KITTITAS COUNTY FIRE MARSHAL'S OFFICE

November 7, 2016

Re: Potucek (BL-16-00016)

LOTS 1 THROUGH 8, HAAGEN'S REPLAT  
PART OF SECTION 1, TOWNSHIP 17 NORTH, RANGE 18 EAST, W.M.

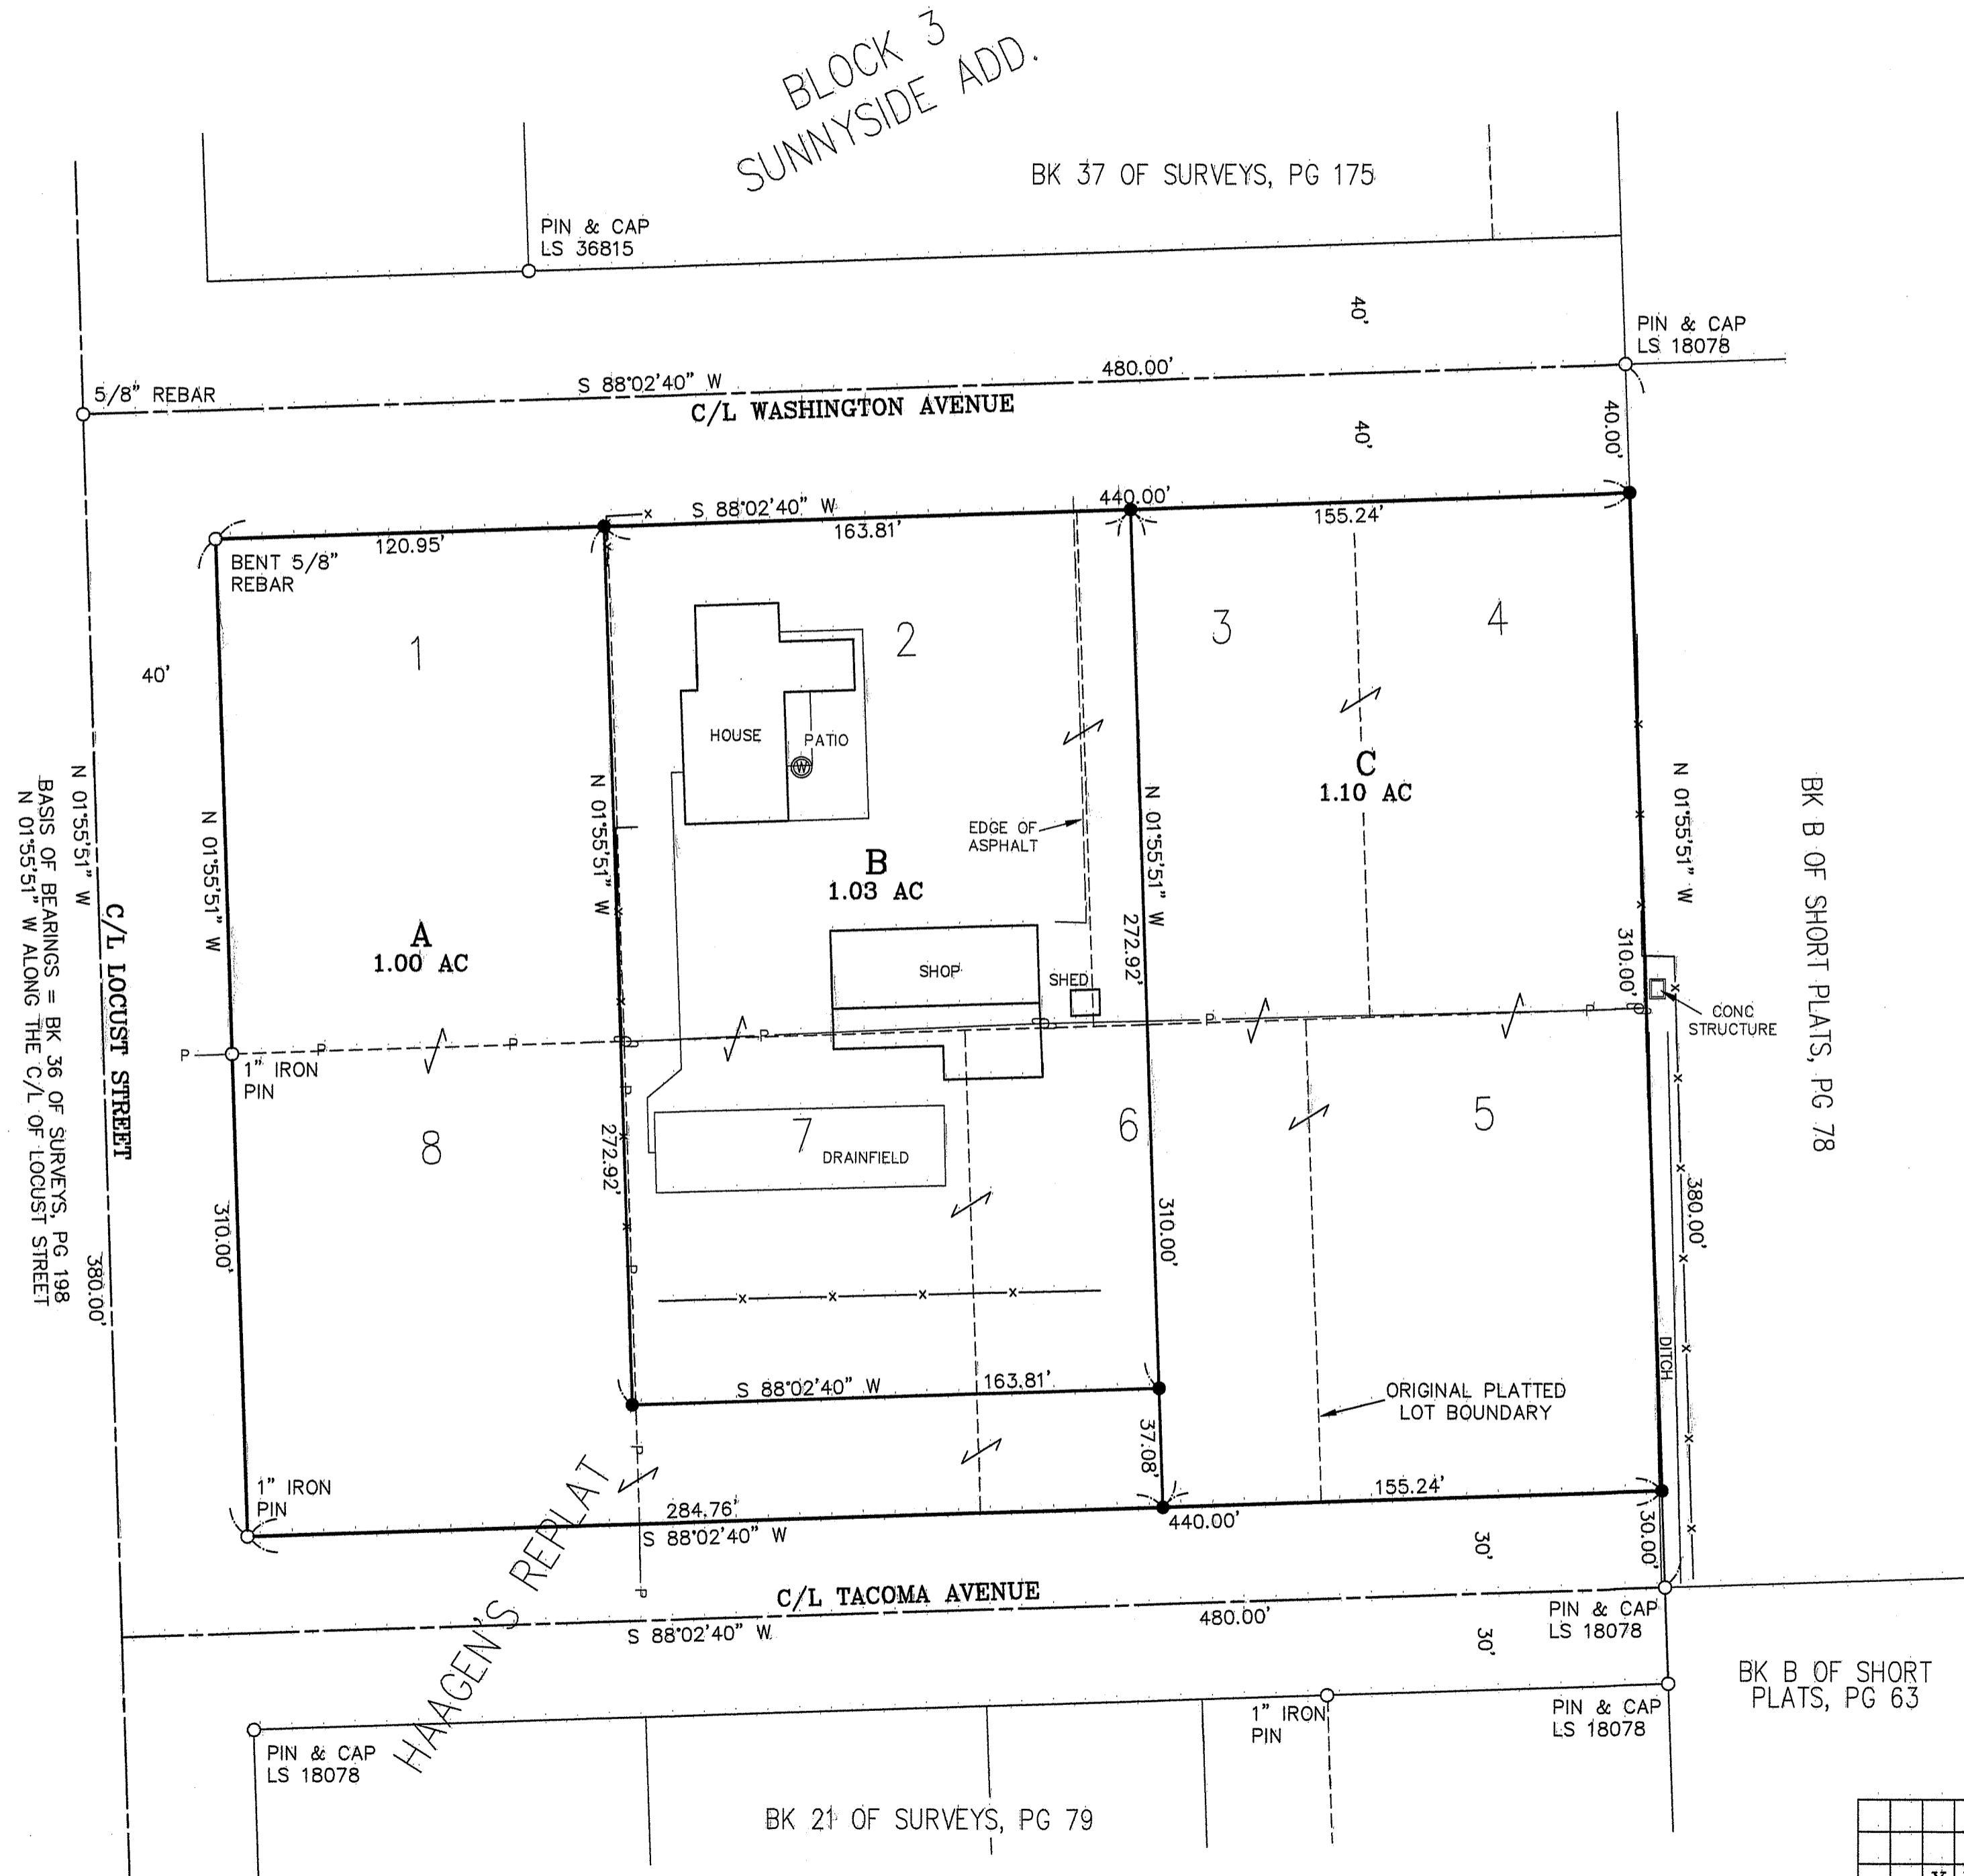
- Ensure that boundary line adjustments do not infringe upon existing structures, to include propane tanks, etc.
- Ensure adequate access for fire apparatus. Any driveways or access points created based off the new lot configurations shall comply with Kittitas County Code 20.02.030.
- All future development must comply with the International Fire Code.
